CITY OF ALBUQUERQUE

Re: Safe House Distilling Co.
616 Gold SW, 87102
Traffic Circulation Layout
Engineer's/Architect's Stamp 12-18-18 (K14D115)

Based upon the information provided in your submittal received 12-19-18, the above referenced plan cannot be approved for Building Permit until the following comments are addressed:

TRAFFIC CIRCULATION LAYOUT

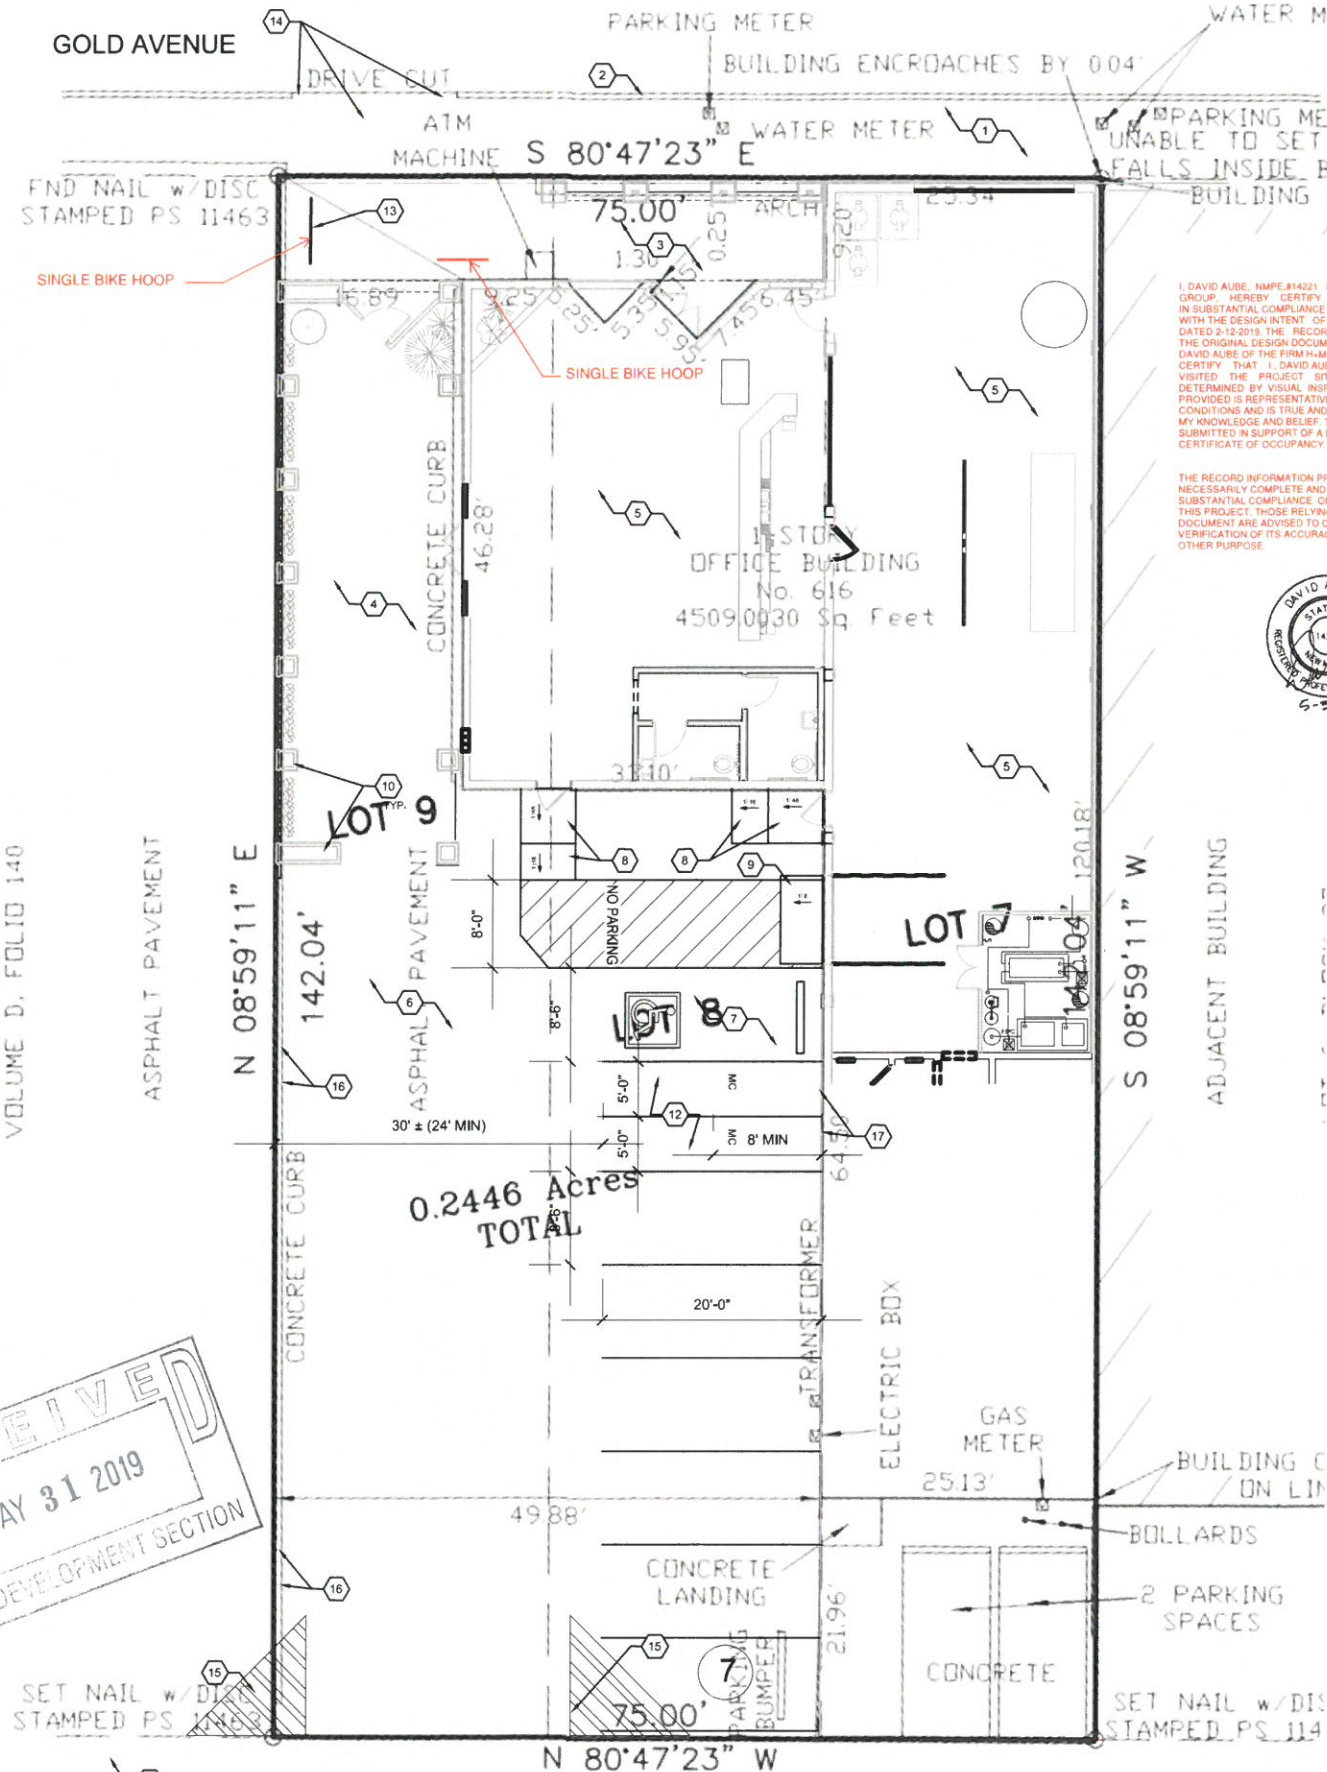
1. The handicap accessible spaces must be a minimum of 8.5 ft. in width.
2. The handicap accessible spaces must include an access aisle. Van accessible aisles should be 8ft wide; all others should be 5ft wide. (Please dimension the accessible aisle).
3. Motorcycle parking spaces shall be designated by its own conspicuously posted upright sign, either free-standing or wall mounted per the IDO code.
4. Unused curb cuts must be replaced with sidewalk and curb & gutter. A build note must be provided referring to the appropriate City Standard drawing.
5. Add a note stating "All broken or cracked sidewalk must be replaced with sidewalk and curb & gutter." A build note must be provided referring to the appropriate City Standard drawing.
6. Please include one copy of the traffic circulation layout at the next submittal.
